# KIRKLEES METROPOLITAN COUNCIL INVESTMENT & REGENERATION SERVICE

### DELEGATED DECISION TO DETERMINE PLANNING APPLICATIONS

| Reference No:         | <b>2023/62/93288/W</b>                                                                                                                                                                                   |
| Site Address:         | 12, Ellison Street, Crosland Moor, Huddersfield, HD4 5DS                                                                                                                                                 |

Rear Elevation SW
1 : 100

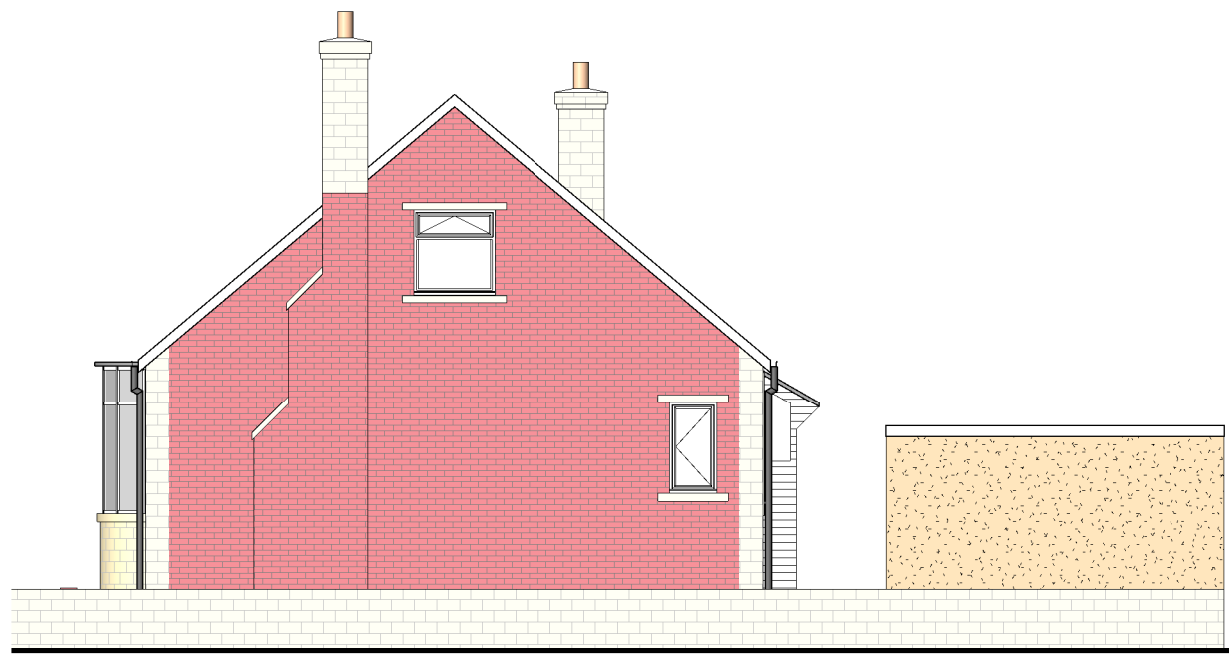
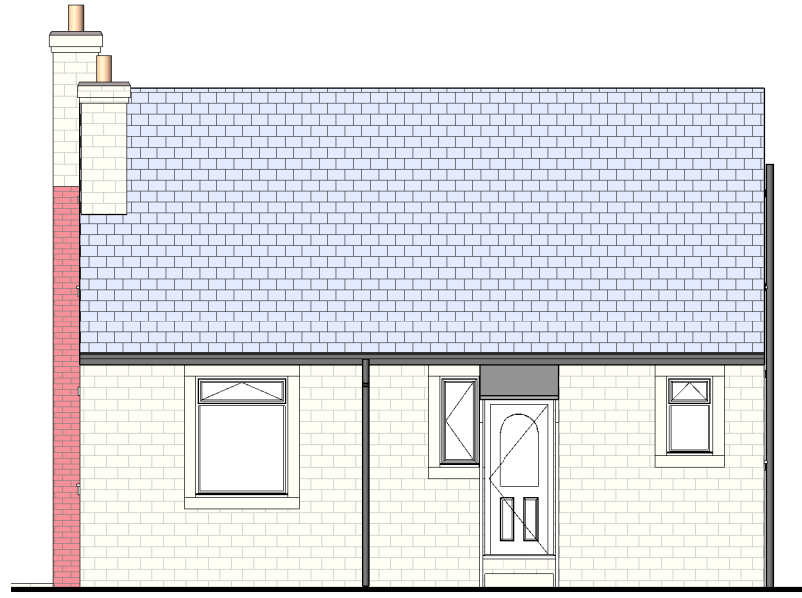
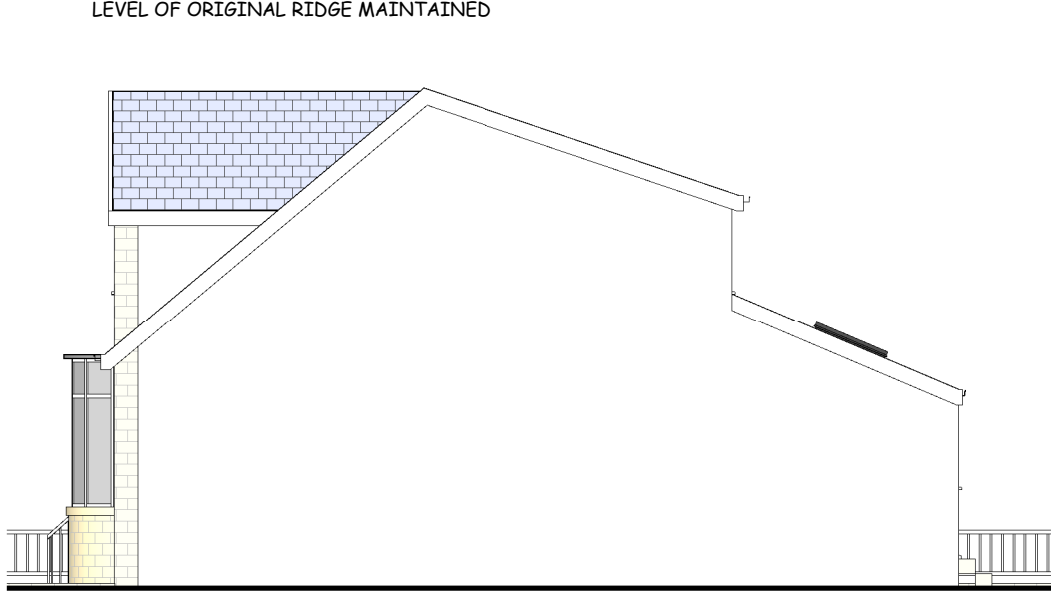
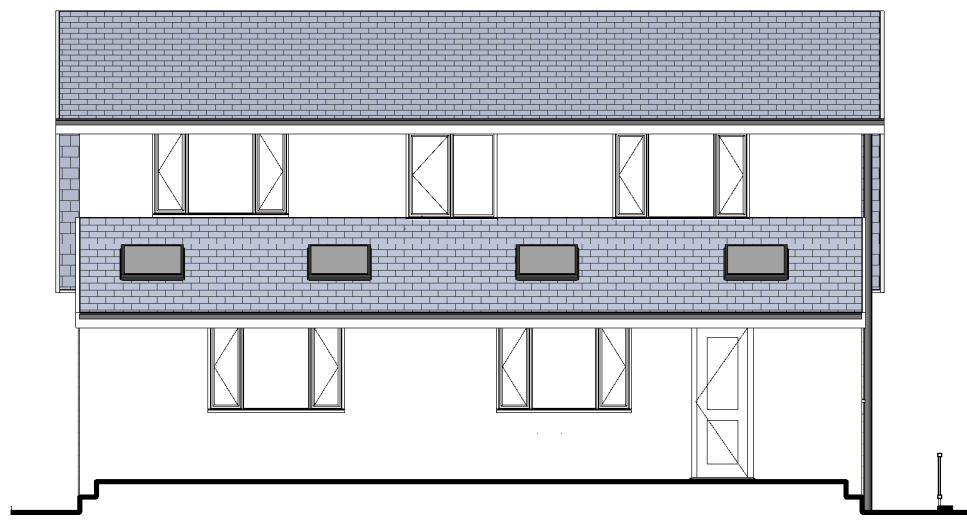
Whilst the submitted plans annotate on the proposed north west and front elevation that 'level of original ridge maintained', the roofing form above the dwelling will undergo substantial alterations, especially to the rear elevation, where the eaves height will be increased from 2.9 metres to 5 metres.

Two dormer gable projections would be installed to the front roof panel and three regular windows would be installed to the rear elevation at first floor level. These modifications would create first floor accommodation, with the floor plans showing four bedrooms, an ensuite and a bathroom.

There appears to be habitable room windows in the western side elevation of No. 14 Ellison Street. Therefore, it is considered that the proposed alterations to the roof, which present an increase in eaves height to the rear, would result in increased impacts of overbearing and overshadowing for the occupiers of No. 14 Ellison Street, with an increase in bulk/massing directly adjacent to these windows.

The proposed first floor rear windows would serve two of the bedrooms and a bathroom within the interior of the dwelling. These windows would be separated from the boundary of No. 19 Rudding Street by approximately 8 metres and from any first-floor rear windows on No. 19 by approximately 13 metres. Given this separation distance and the locational relationship between No. 12 Ellison Street and No. 19 Rudding Street, it is not considered that the proposed new first floor windows would result in overlooking to this neighbouring dwelling, given that the new windows would not sit directly adjacent to the rear windows on No. 19 Rudding Street.

However, given the topographical relationship between No. 12 Ellison Street and No. 19 Rudding Street, it is considered that the proposed first floor rear windows would result in undue levels of overlooking into the rear garden amenity space of No. 19 Rudding Street. This would impact negatively upon the levels of privacy to the outdoor amenity space of this neighbouring property.

Side Elevation SE
1 : 100

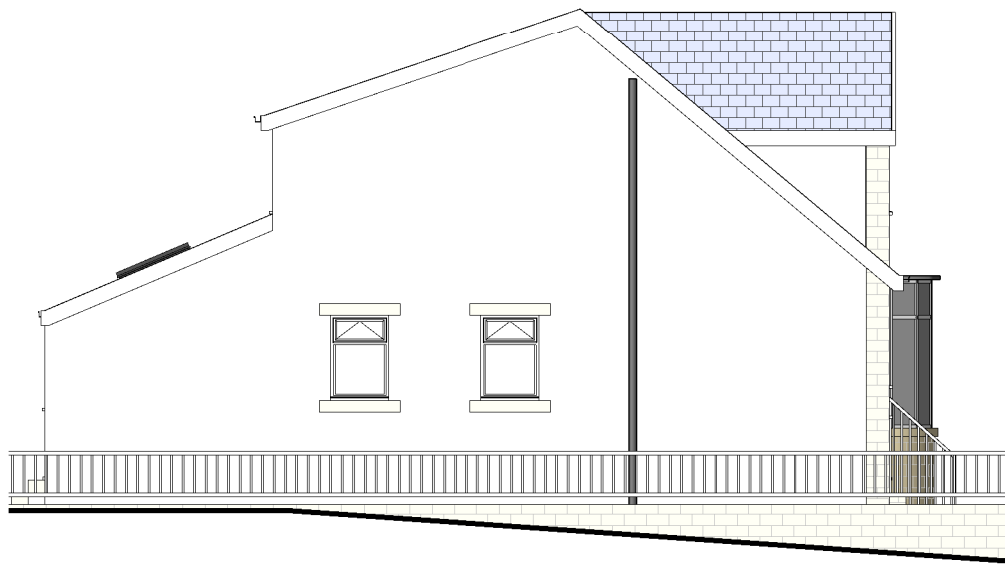
The existing fenestration details to the front elevation would largely as existing, other than the increase in size of one of the windows. The glazing to the south eastern side elevation would be altered, removing the existing windows and installing two windows at ground floor level to serve a bathroom and utility internally. The existing windows to the north western elevation would be removed and this elevation would remain blank.

The proposal to No. 12 Ellison Street is not considered to introduce any glazing to face toward No. 14 Ellison Street, which would present any impacts to privacy over and above the existing relationship. The existing two windows to the south eastern facing elevation which serve a bathroom and bedroom are to be replaced by two windows of the same size/scale which will serve a bathroom and utility (both considered non-habitable rooms).

Block Plan
1 : 500

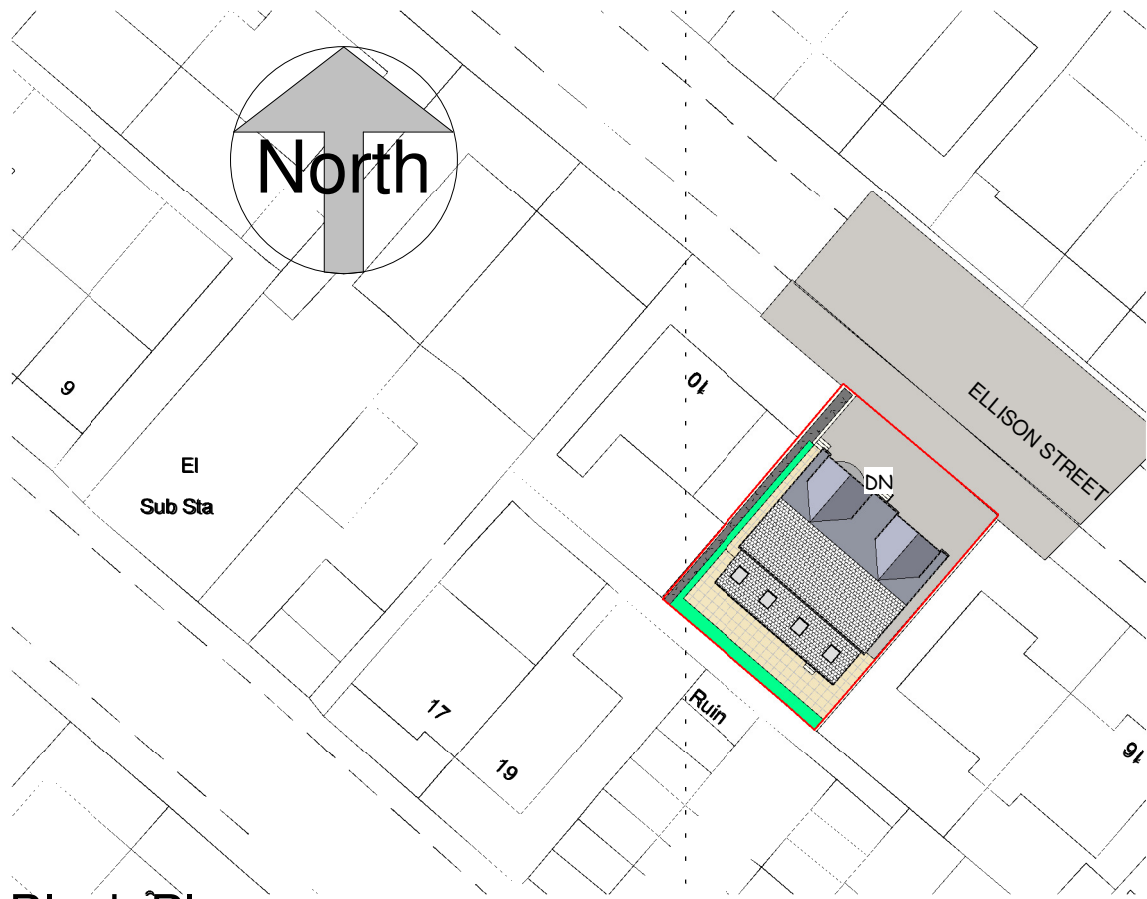
The proposal would result in the front amenity space being completely devoted to pedestrian access and vehicular parking. The proposed parking spaces would require a parallel parking manoeuvre to enable a vehicle to be parked off street, two such spaces are shown with a gap between of 2m between. The spaces would be 5m x 2.7m in size.

The practicality of using both spaces would be problematic and there is a high likelihood both spaces would not be readily (or practically be able to be) used. In essence it is considered that the proposal would lead to one vehicle being parked off street with other vehicles parking on street, albeit potentially across the width of the extended driveway (given the proposal incorporates the creation of a dropped curb the full frontage of the property).

Front Elevation NE
1 : 100

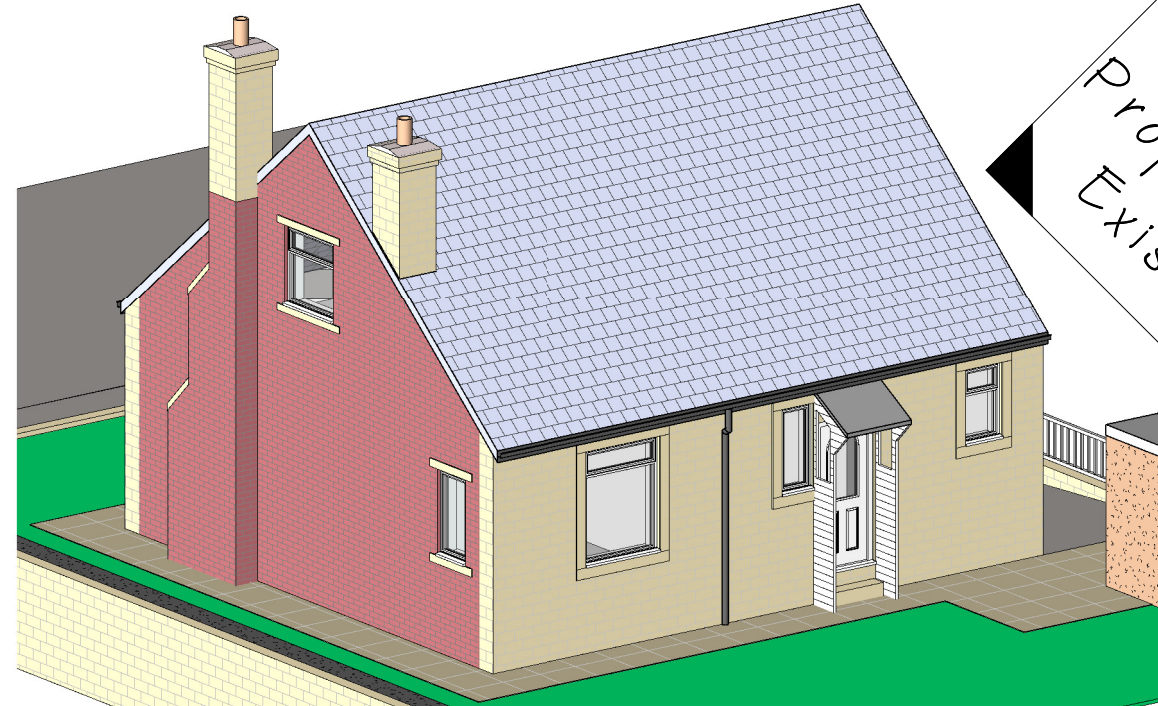
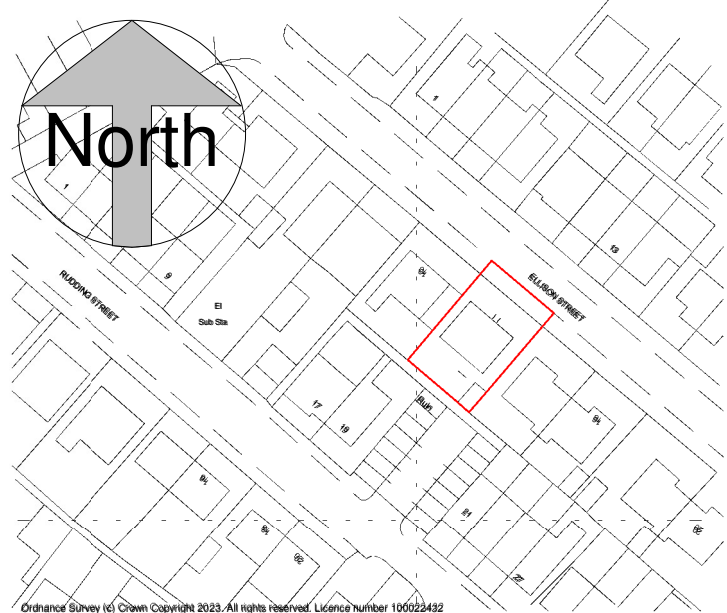
The scale, massing and design of the proposed first floor extension would not be considered a subservient addition visually and would be considered to result in a loss of character to the existing ‘true’ bungalow. Cumulatively, the works to the roof and the gable projecting front dormers would be considered to present an undue level of bulking and massing. It is considered that, together, these developments would appear incongruous and out of proportion with the size/scale and form of the existing dwelling, which itself has been extended since it was originally built. For these reasons, from a visual amenity perspective, the cumulative impact of the proposals would lead to the overdevelopment of the property, whereby it is considered that the proposed development would appear out of keeping with the scale of the host building.
